16 December 2019

MARTIN PLACE OSD DRP – SESSION 12 10.12.19

At the last DRP, the panel recommended amending the design of the South Tower by the addition of vertical fins (or any other means) to reduce or eliminate glare from the northern façade onto the western end of Martin Place near the Cenotaph. The recommendation was adopted as a Condition of Consent and DRP 12 was convened to seek the panel's endorsement of the changes and discharge the condition.

Proposed plan detail showing revised alignment of the facade of 39 Martin Place.

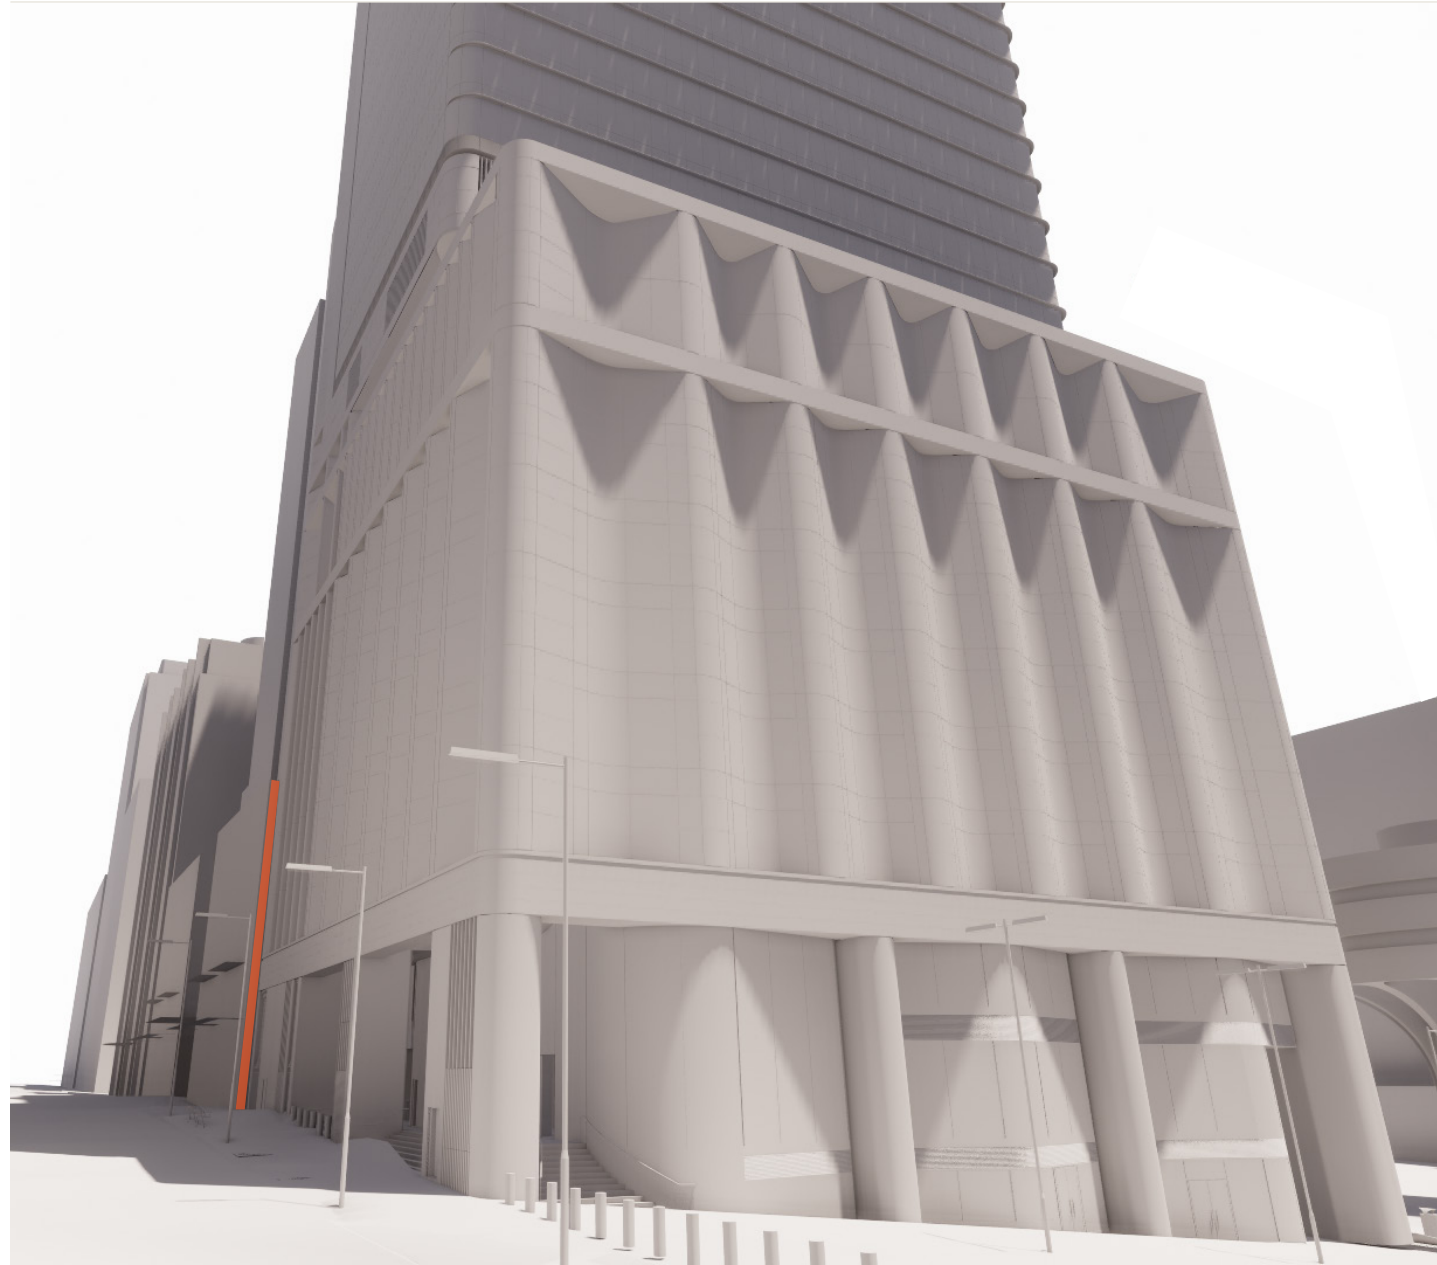
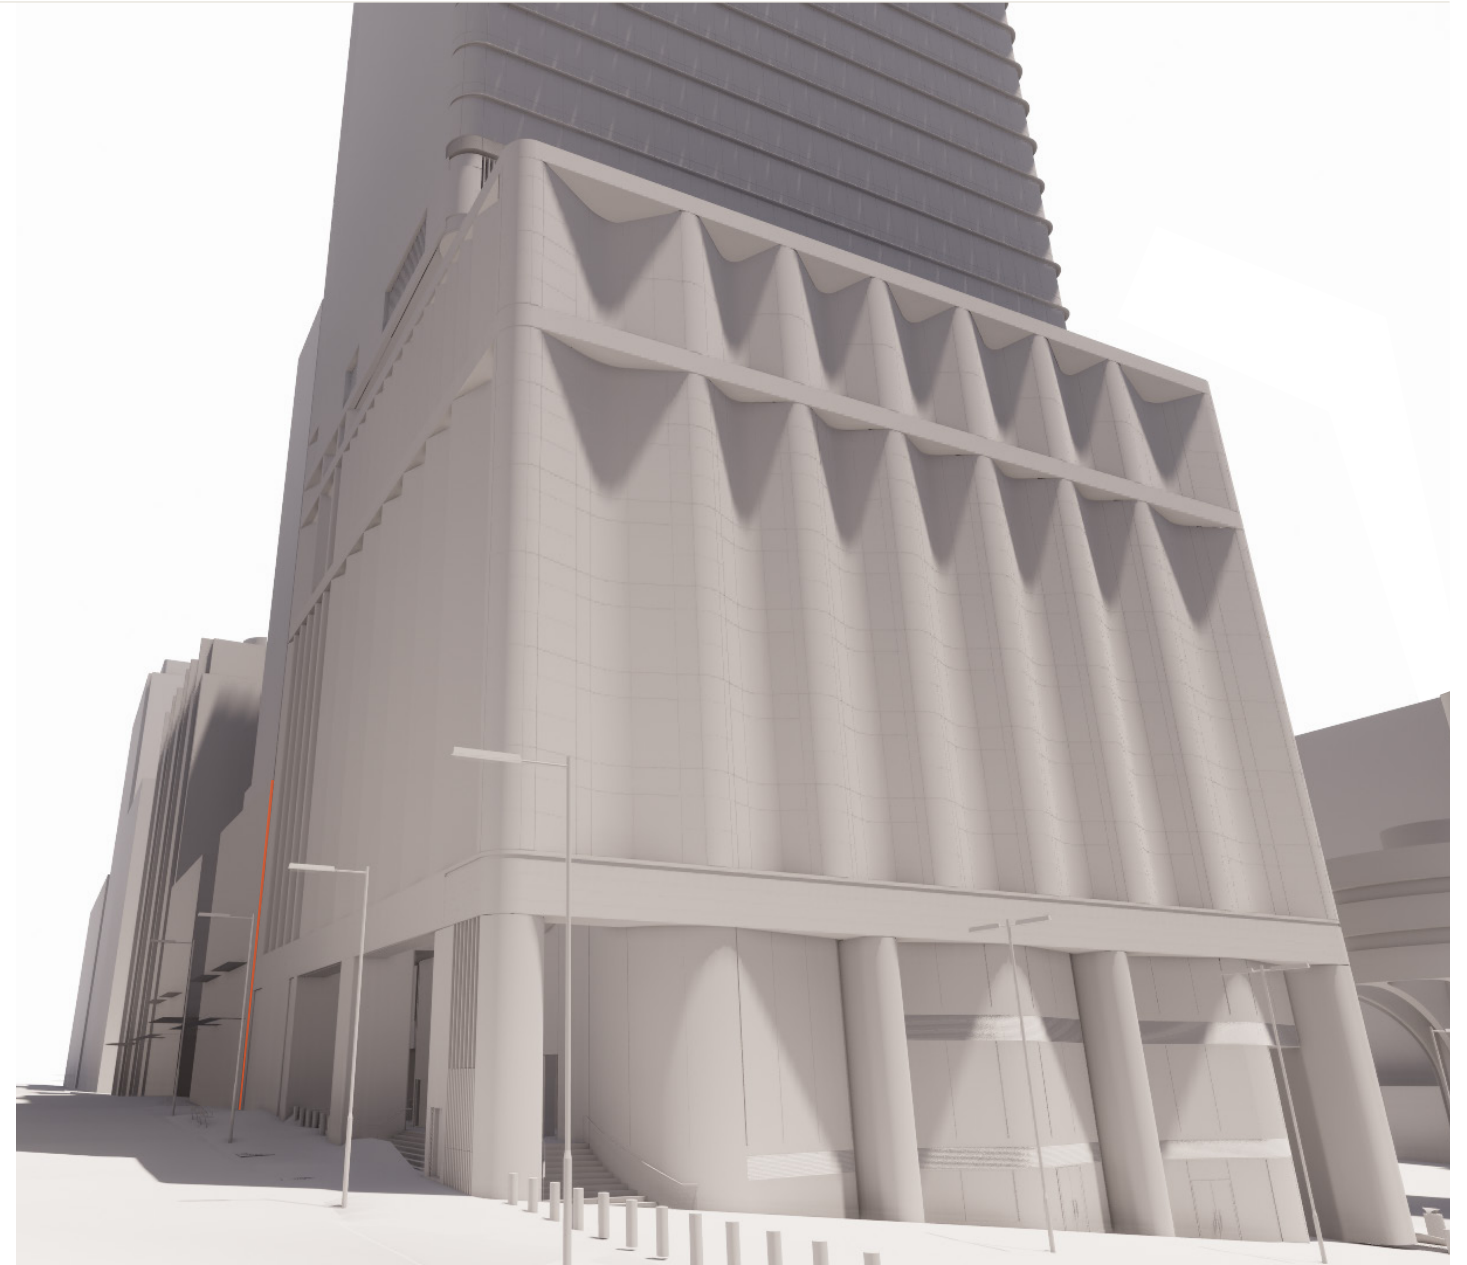
Tzannes explained that due to technical drafting issues the eastern façade of the South Tower does not align with the existing street wall of Elizabeth Street.

An amended proposal was presented which seeks to rectify the discrepancy by realigning the eastern façade with the site boundary and the dominant street wall, a change of approximately 600mm.

The panel supports this change which reflects previous discussions around the importance of the street wall and sits within the approved building envelope.

Flux Recommendation - single 600mm deep horizontal solar shade with 110mm vertical fins (equivalent to 90mm fins at 1m centres)

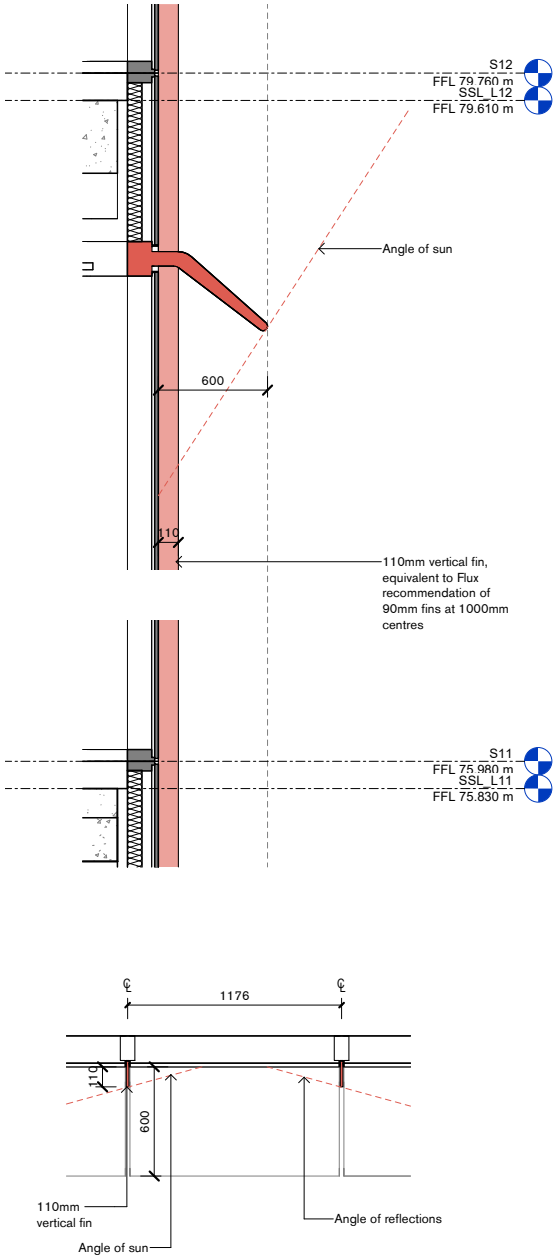
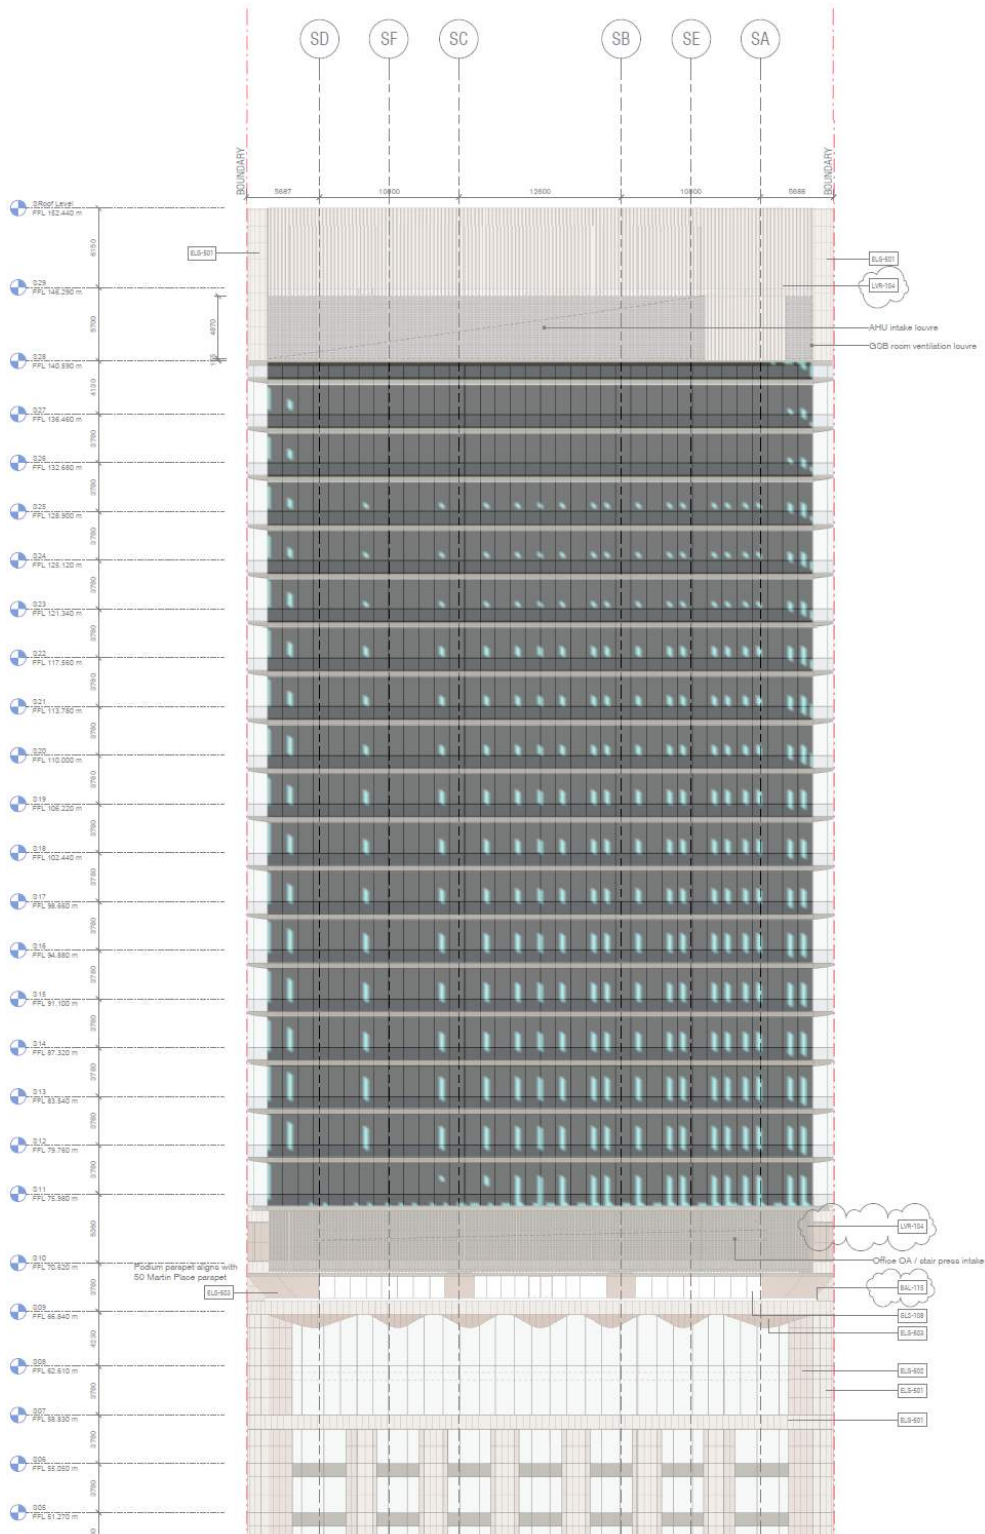
The first proposal adds vertical fins to the northern façade between the horizontal shading of the approved tower. This proposal eliminates glare completely from the critical area around the Cenotaph. Proposal two, adds a second band of horizontal shading immediately below the first. This proposal significantly reduces glare in this area.

View of North facade
Proposed Revised Architectural Solution for Endorsement -
double 600mm deep horizontal solar shades

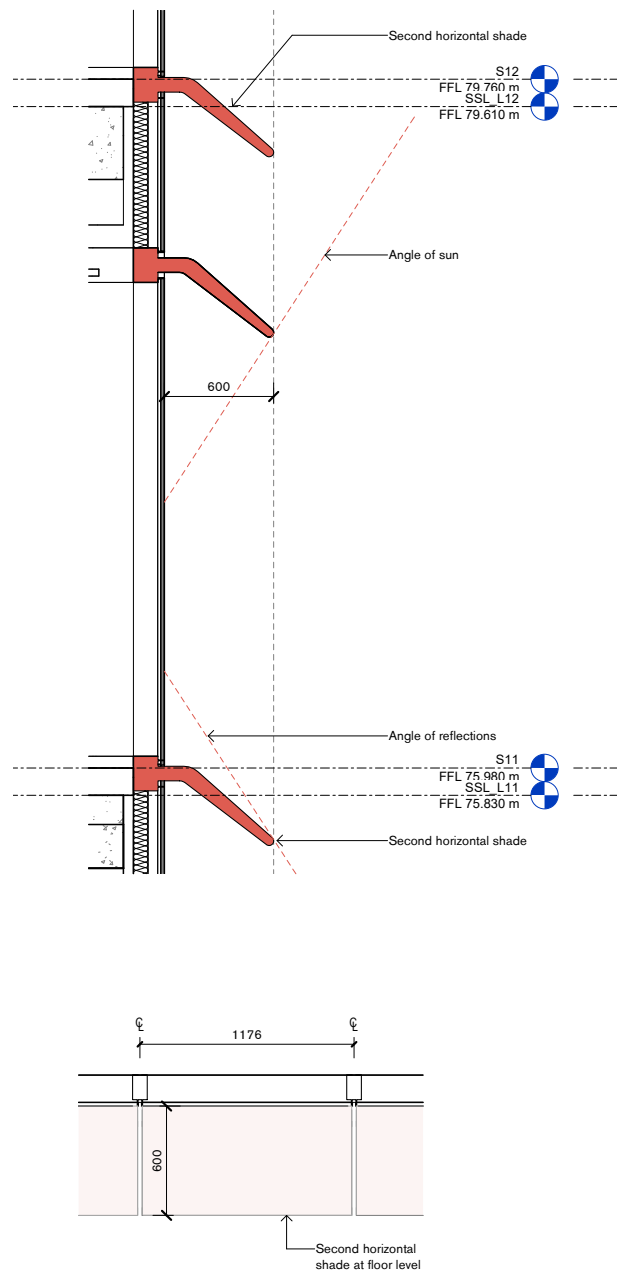
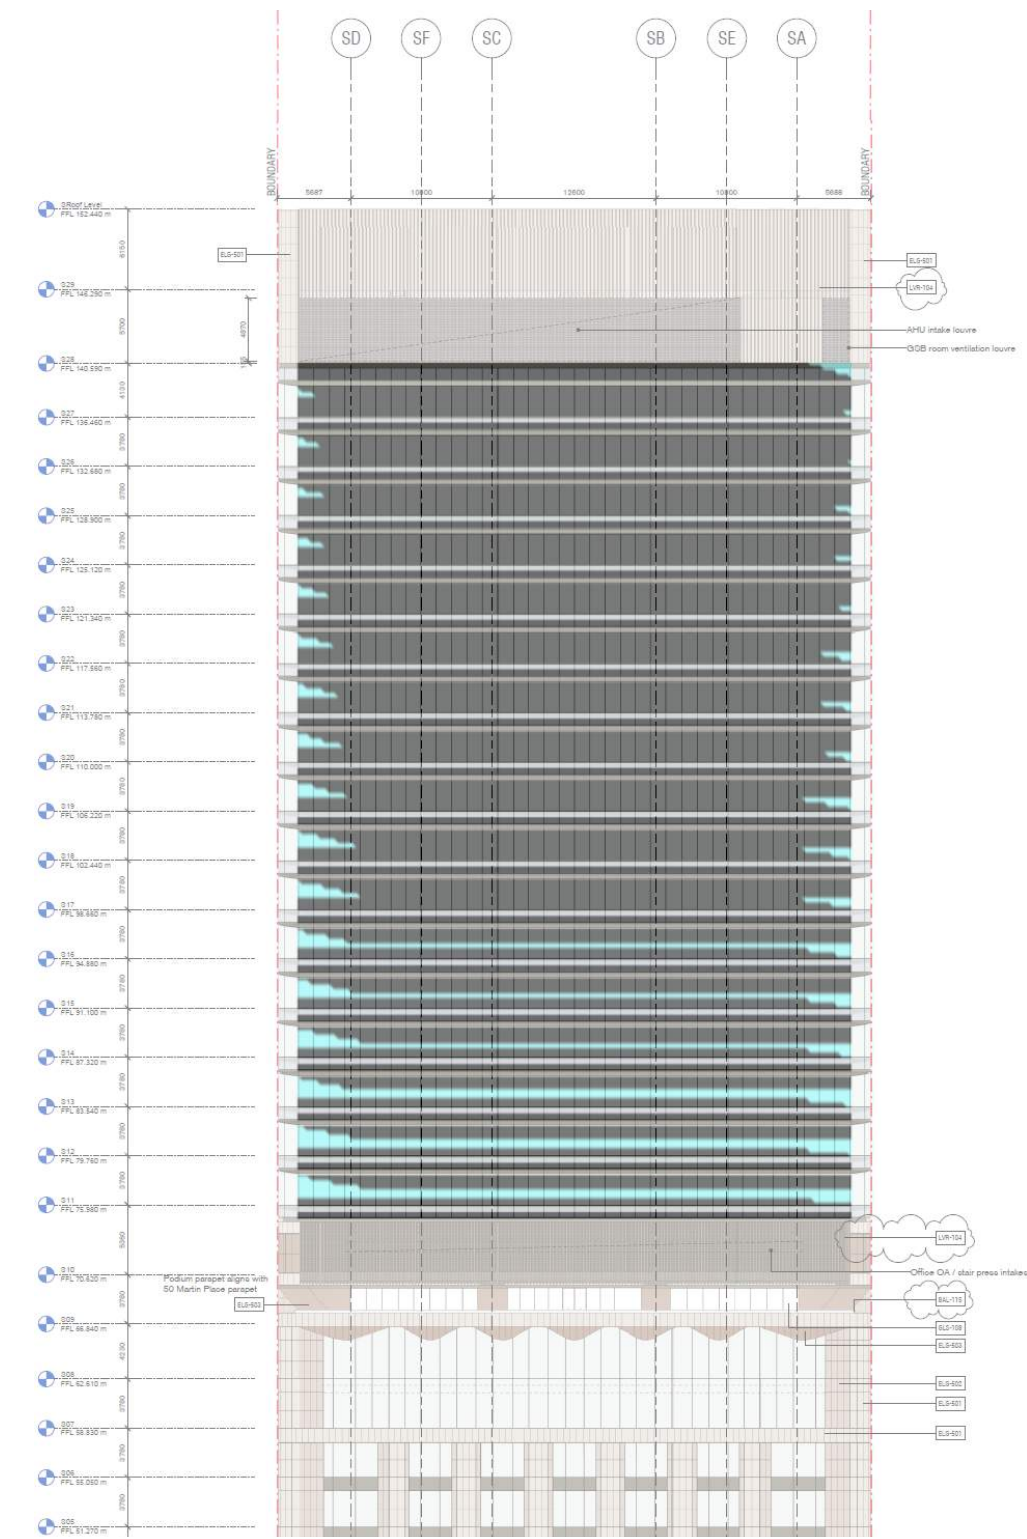
The panel acknowledges and commends the effort of all parties to resolve this issue and endorses the addition of a second band of horizontal shading to the northern façade of the South Tower. While the change does not eliminate glare completely, there is a significant reduction. It is also understood that any remaining glare impacts are minor and will not conflict with major events associated with the Cenotaph, including ANZAC and Remembrance Days.

The panel considers the addition of a second band of horizontal shading to be a solution that reduces glare and strengthens the architectural expression of the tower.
